KITTITAS COUNTY FIRE MARSHAL'S OFFICE

Re: Leenvert (BL-14-00015)

After conducting a review of the recent changes to the above named project, I have the following comments:

LOT LINE ADJUSTMENT

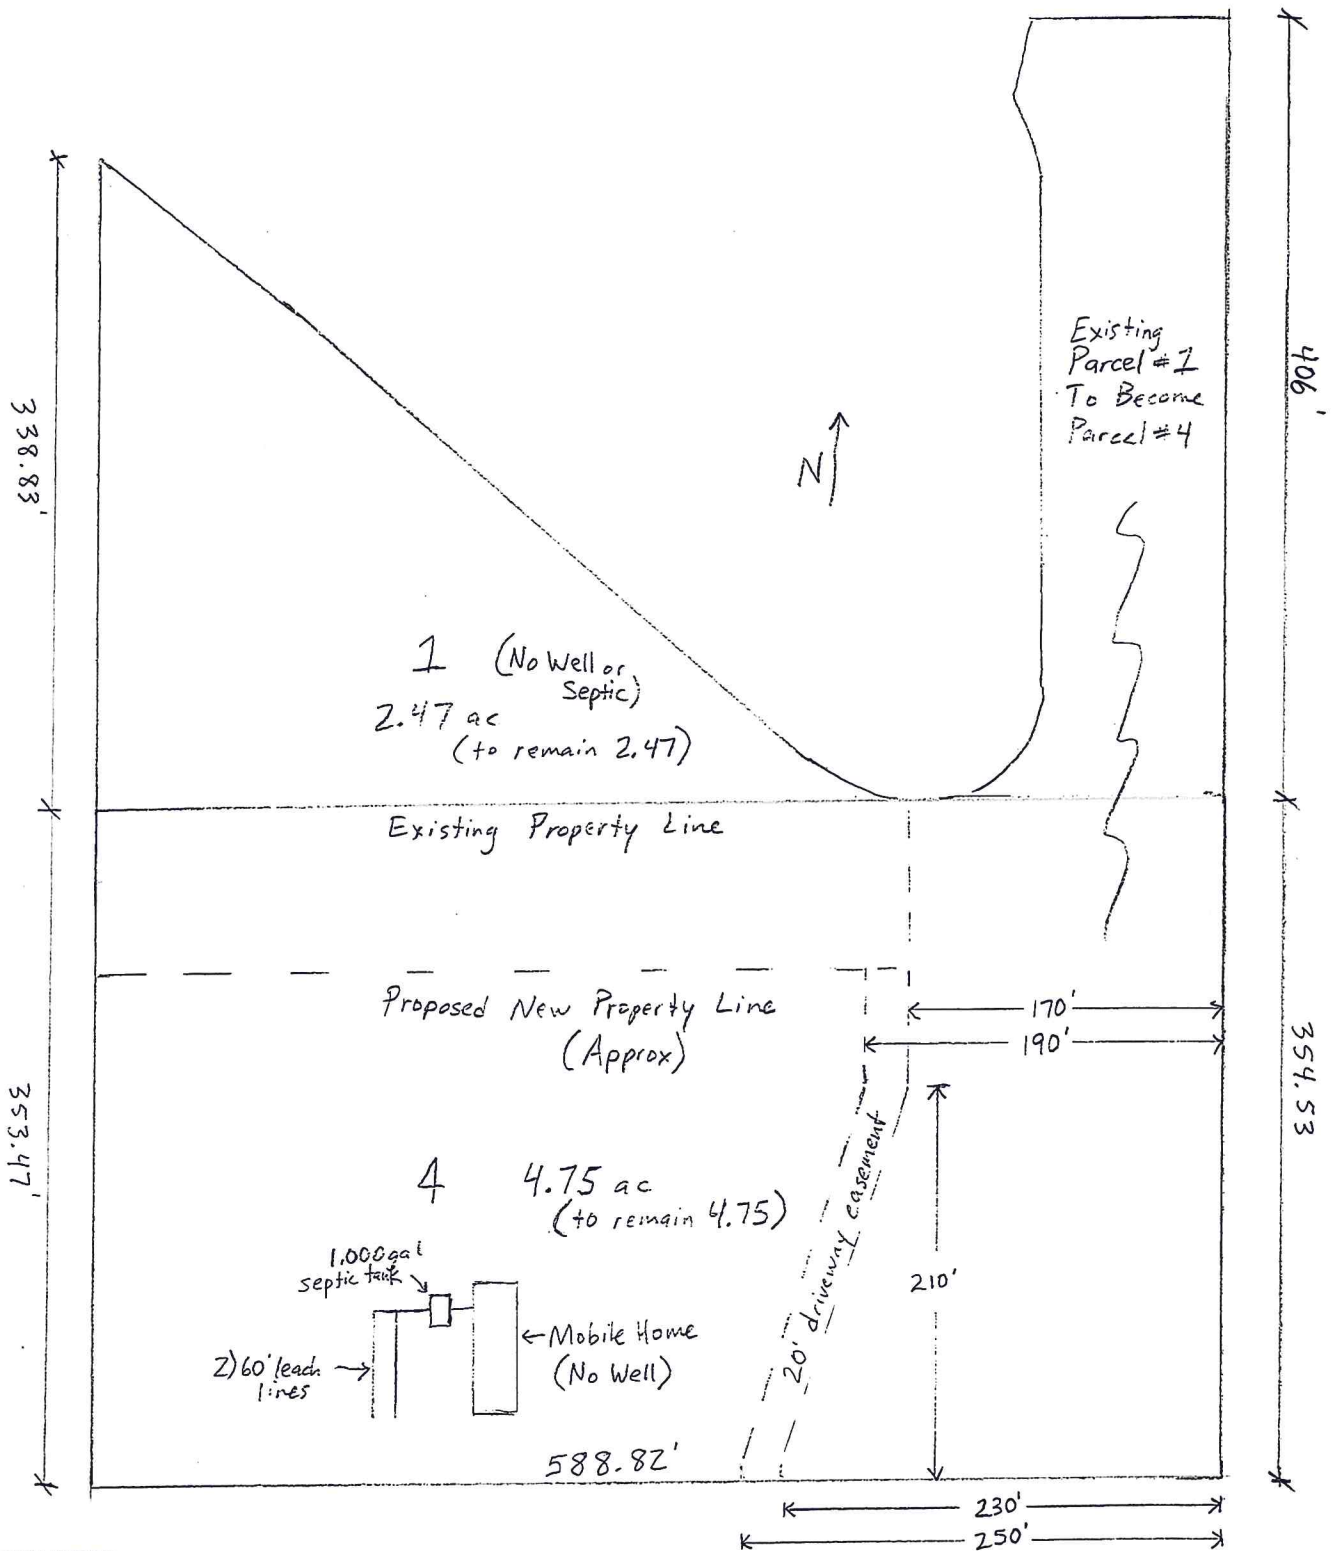
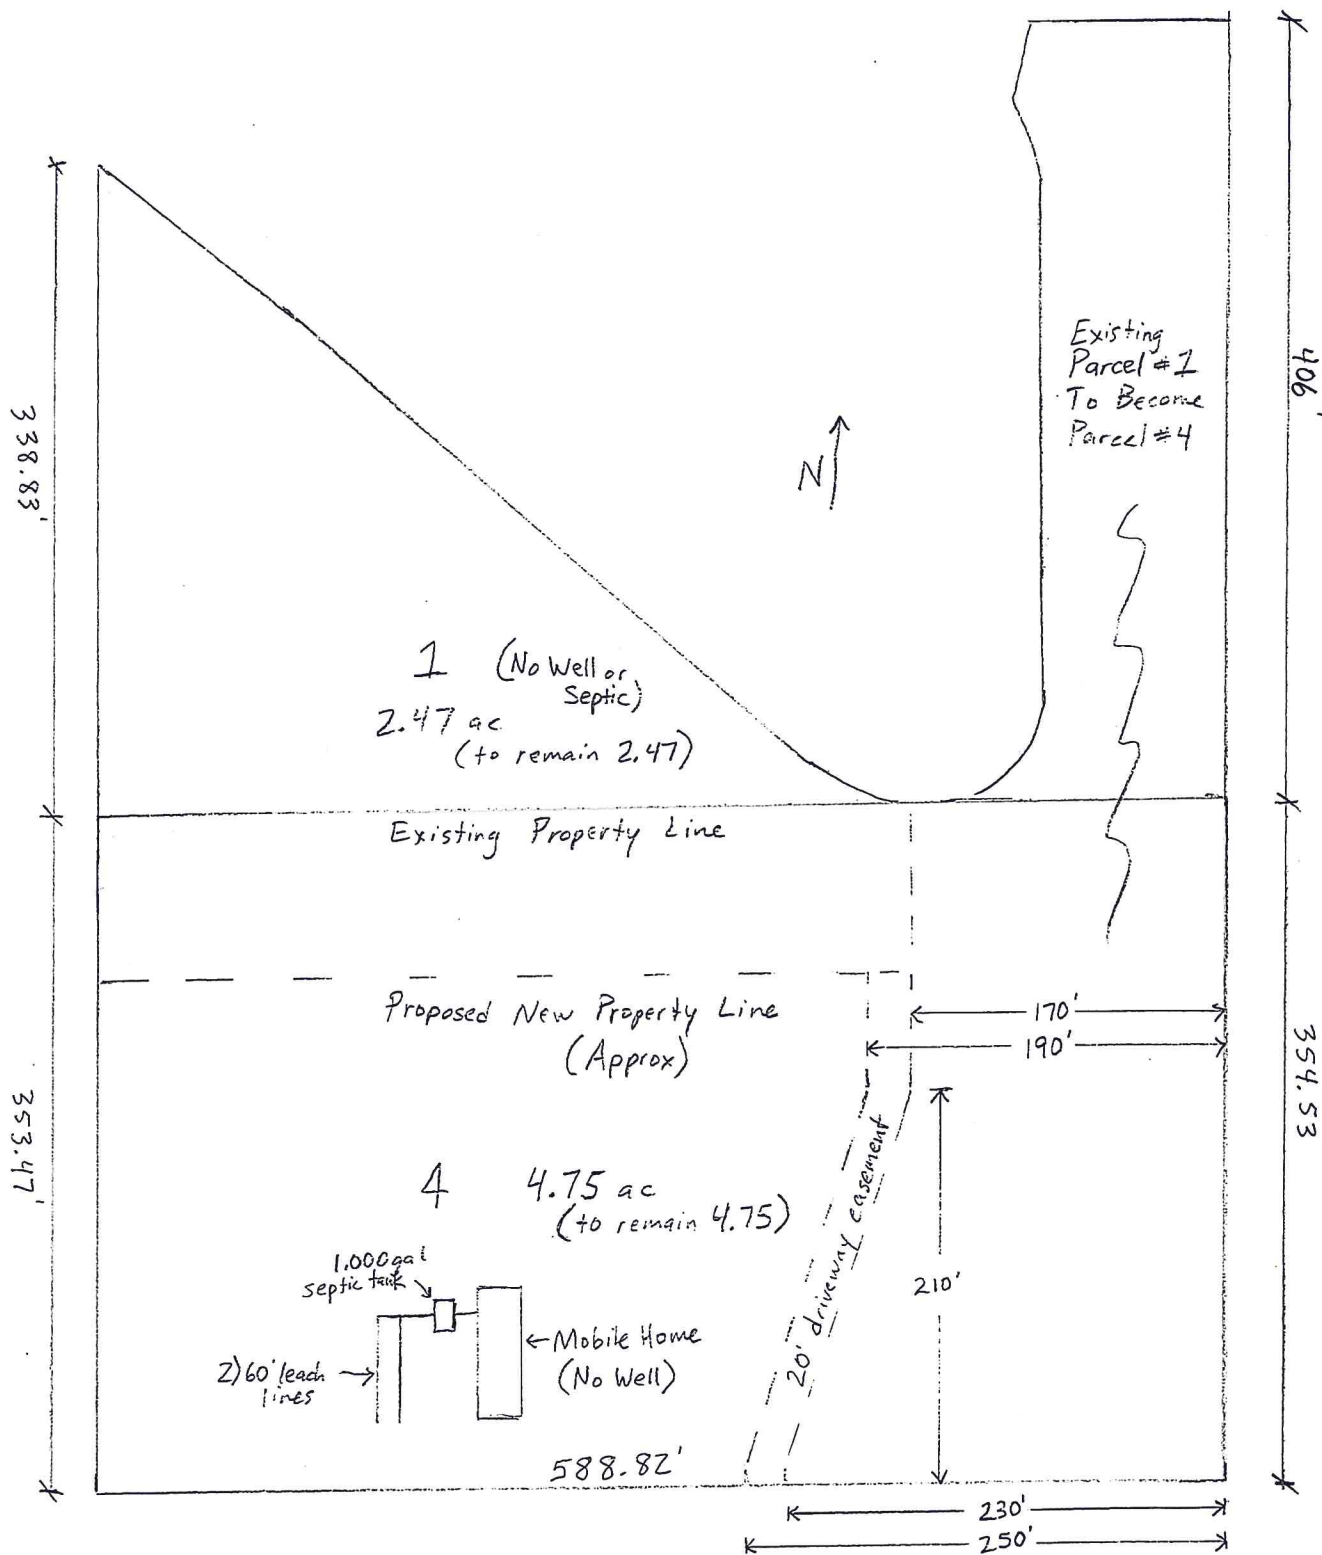
- Ensure that boundary line adjustments do not infringe upon existing structures, to include propane tanks, etc.
- Ensure adequate access for fire apparatus. Any driveways or access points created based off the new lot configurations shall comply with Kittitas County Code 20.02.030.
- All future development must comply with the International Fire Code.
